## Appeal Decision

**Appeal Ref: APP/R5510/D/23/3328157**

**493 Bath Road, Longford, Heathrow, Hillingdon UB7 0EN**

- The appeal is made under section 78 of the Town and Country Planning Act 1990 against a refusal to grant planning permission.
- The appeal is made by Mr Jay Vara against the decision of the Council of the London Borough of Hillingdon.
- The application Ref 77891/APP/2023/577, dated 26 February 2023, was refused by notice dated 10 July 2023.
- The development proposed is the formation of a boundary fence and gate, a timber double garage and landscaping.

EXISTING & PROPOSED STREET ELEVATION SCALE 1:100 @ A3

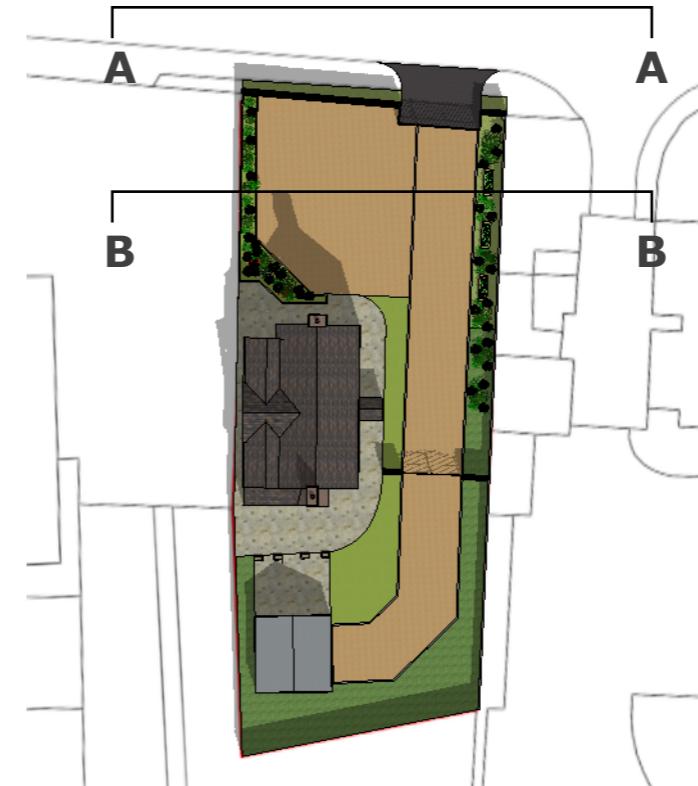
10. However, in the context of this historic cottage, a close boarded timber fence, along with the proposed large area of shingle, would appear incongruous. They would give the front of the site a very stark and suburban appearance, which would fail to respect this historic building's detailed design and its rural origins.

11. Whilst a hedge is also proposed along the front boundary, from the evidence before me it is unclear the extent to which it would obscure the proposed fence. In any event, I cannot be certain that it would be retained, or what height it would be. I thus agree with the Longford Conservation Area Advisory Panel that the proposed fence would be inappropriate for this historic property.

PROPOSED GARAGE ELEVATION SCALE 1:100 @ A3

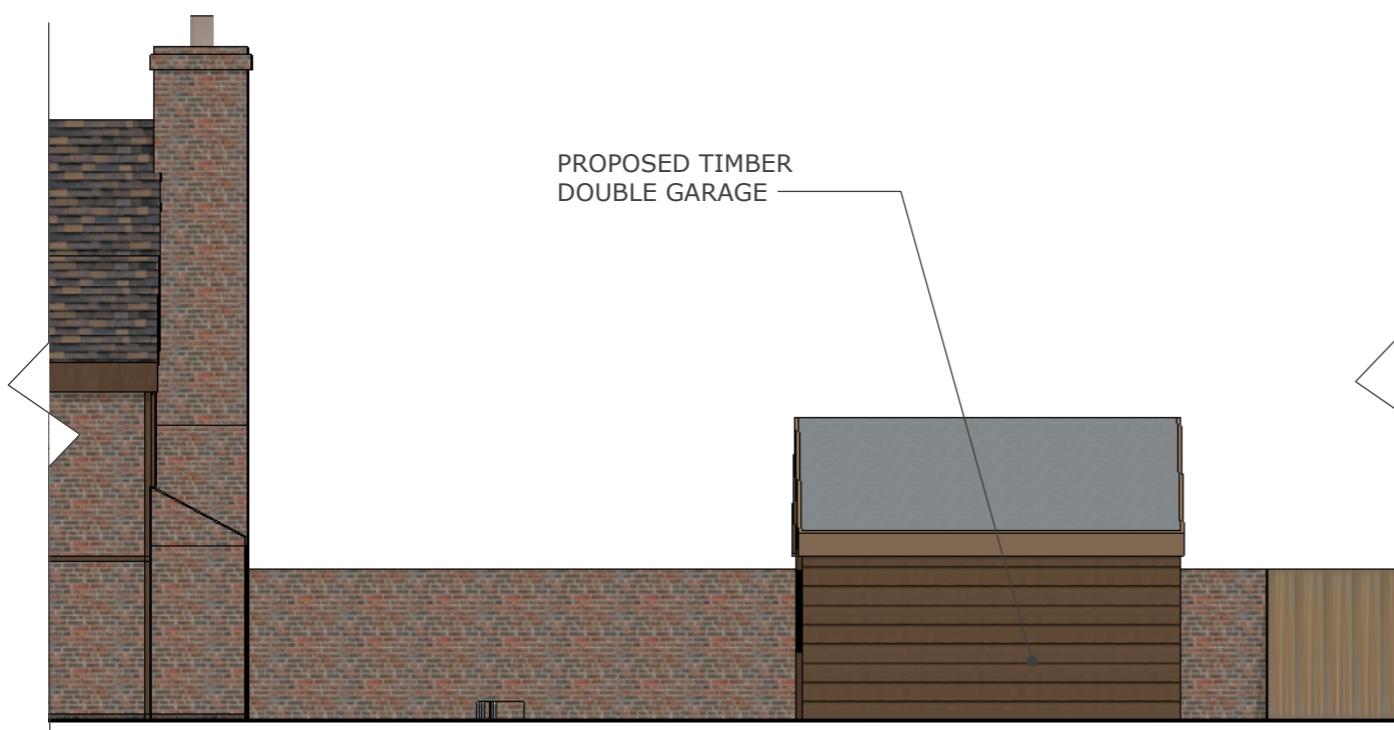
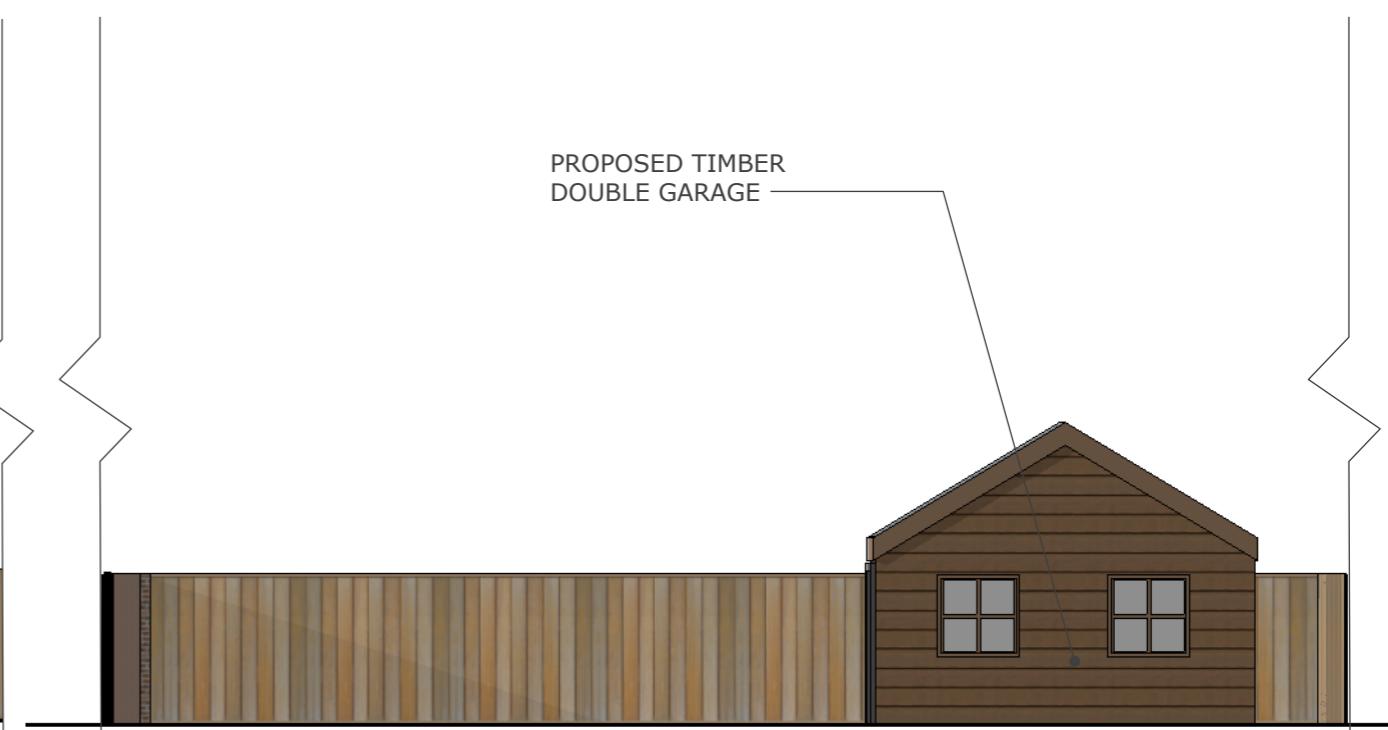
6. The proposed garage would be sited to the rear of the cottage, towards the south-western corner of the plot. Whilst its stained timber walls could match the colour of the cottage's timber frame, the proposed felt roof would be an inappropriate artificial material, which would not reflect the rich texture and palette of the historic cottage; and its shallow-pitched roof would contrast unfavourably with the form of that building.

7. I have very little information regarding the construction and detailing of the proposed garage, including the style and profile of its doors and windows, but from the available evidence, it would appear to have an 'off-the-shelf' appearance which does not take adequate account of, nor reflect, its historic setting.
